From: Marilyn O'Neill <marilynoneill59@gmail.com>
Sent: Tuesday, June 1, 2021 5:28 PM
To: Lauren Anderson
Subject: Comments on short plat application SUB21-002
Attachments: Marilyn's letter.pdf

PURPOSE: Comment on the preliminary short plat application SUB21-002

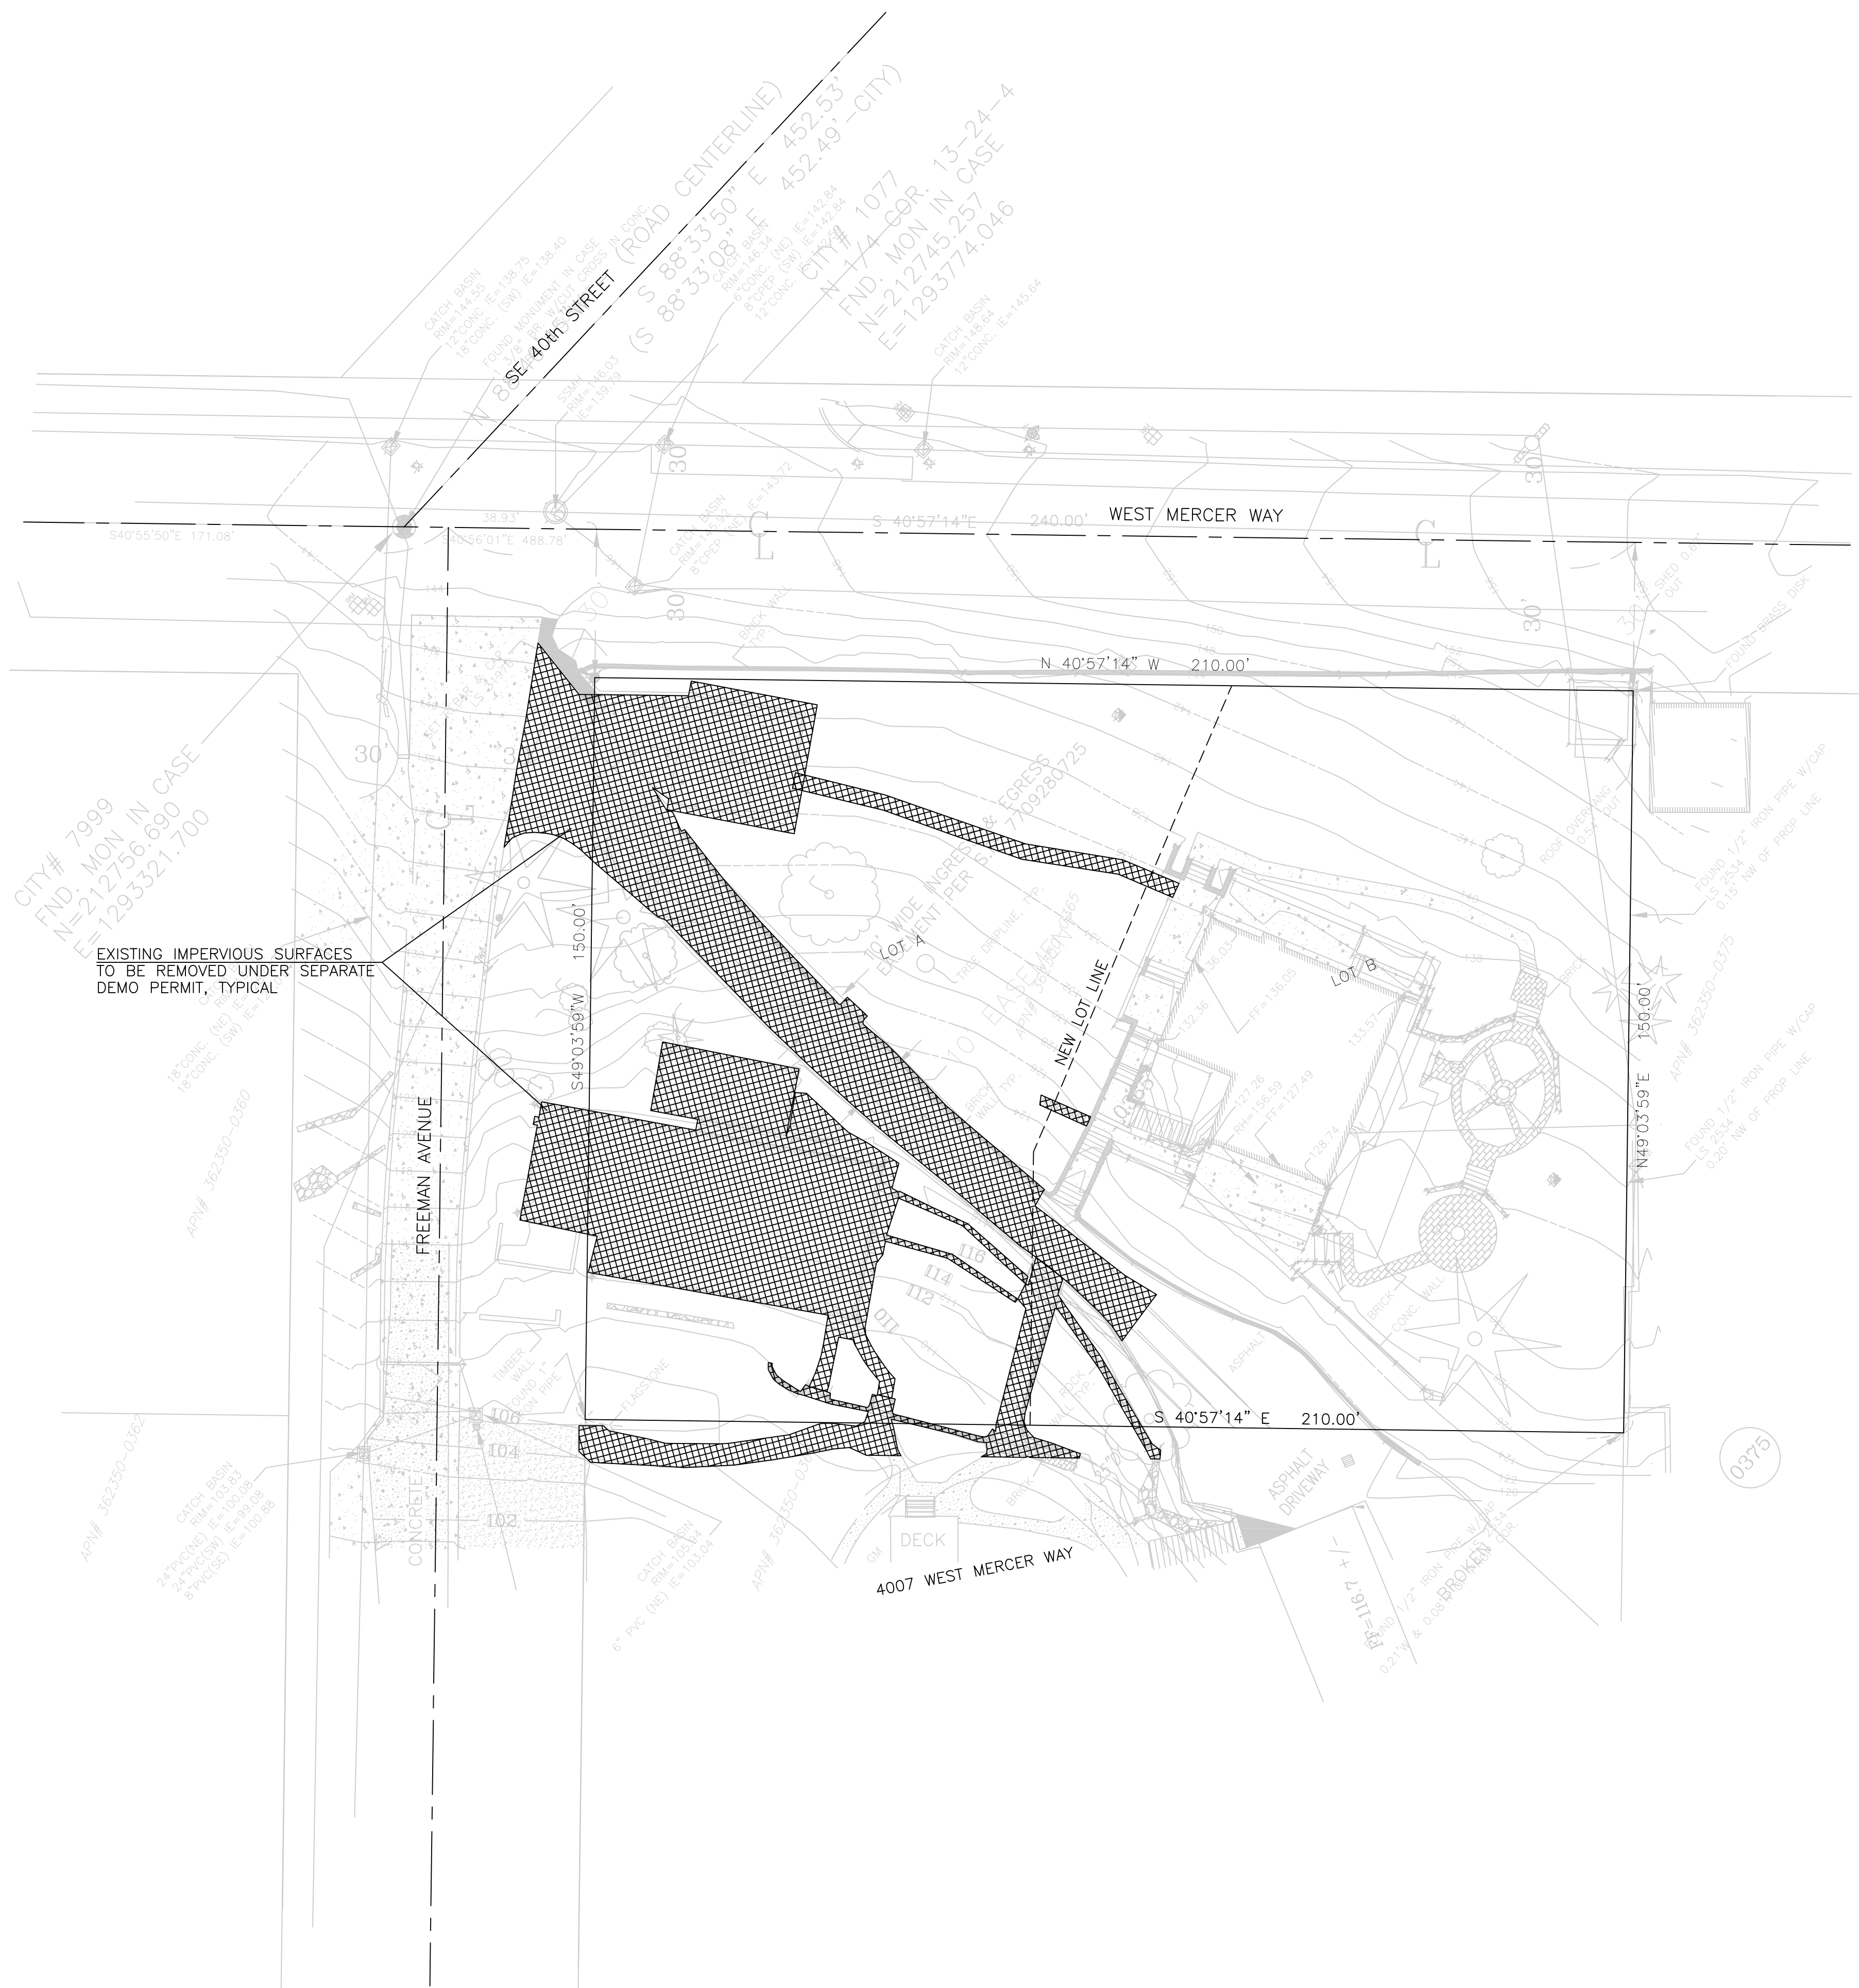
This short plat calls for many changes on the right of way property. Removal of existing driveway, carport and shed next to Greenhouse and then excavation for new driveway. Conversations about finishing the landscaping on the right of way when Freeman Avenue was rebuilt in 2017 need to occur so all understand our responsibilities and opportunities. The ecological impact of adding another house to this piece of land needs to be carefully studied.

TREE TABLE

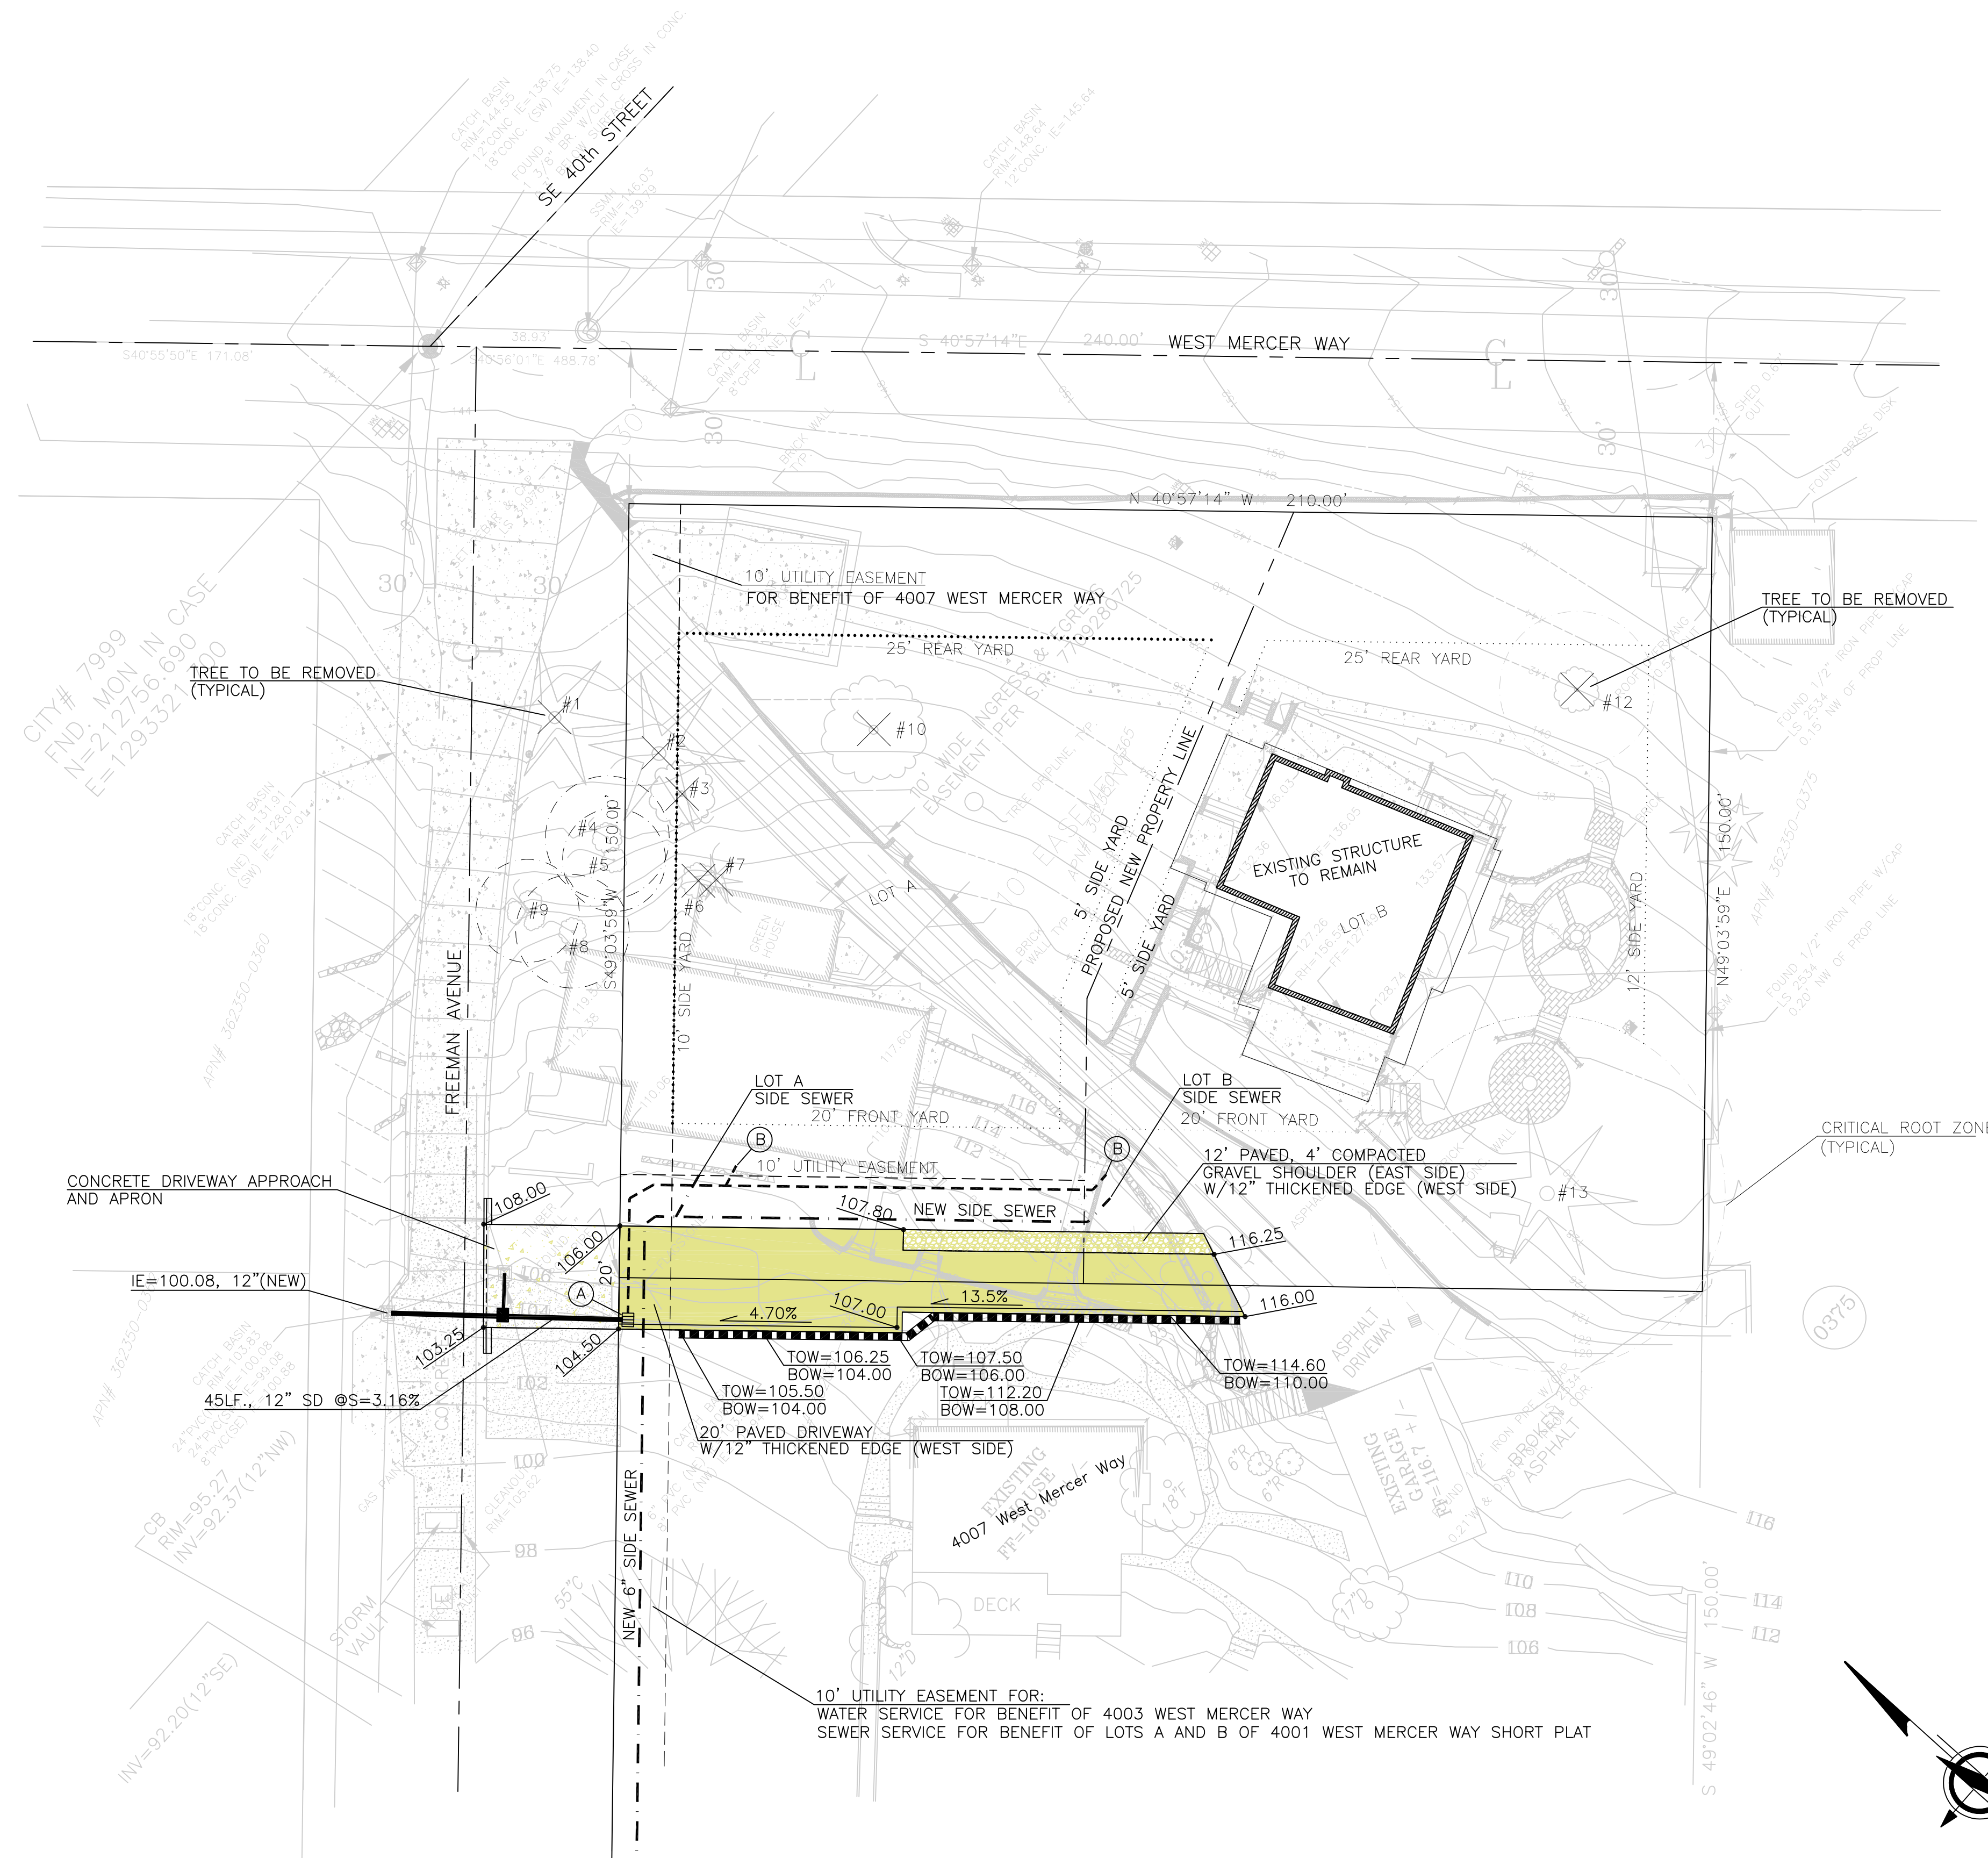
Our neighborhood community realized the need for trees and plantings to help prevent the damage to our sloping lots. To the south of Freeman Avenue many trees created an orchard. Shrubs and an enormous cedar tree also helped to absorb the water. Today, most of the orchard and shrubs have been razed. The cedar tree did not survive the two years of recent construction as trucks and equipment parked on its fragile roots. The plat application calls for more trees to be removed; this seems like an invitation for more slides and water problems. Really need to have more information here.
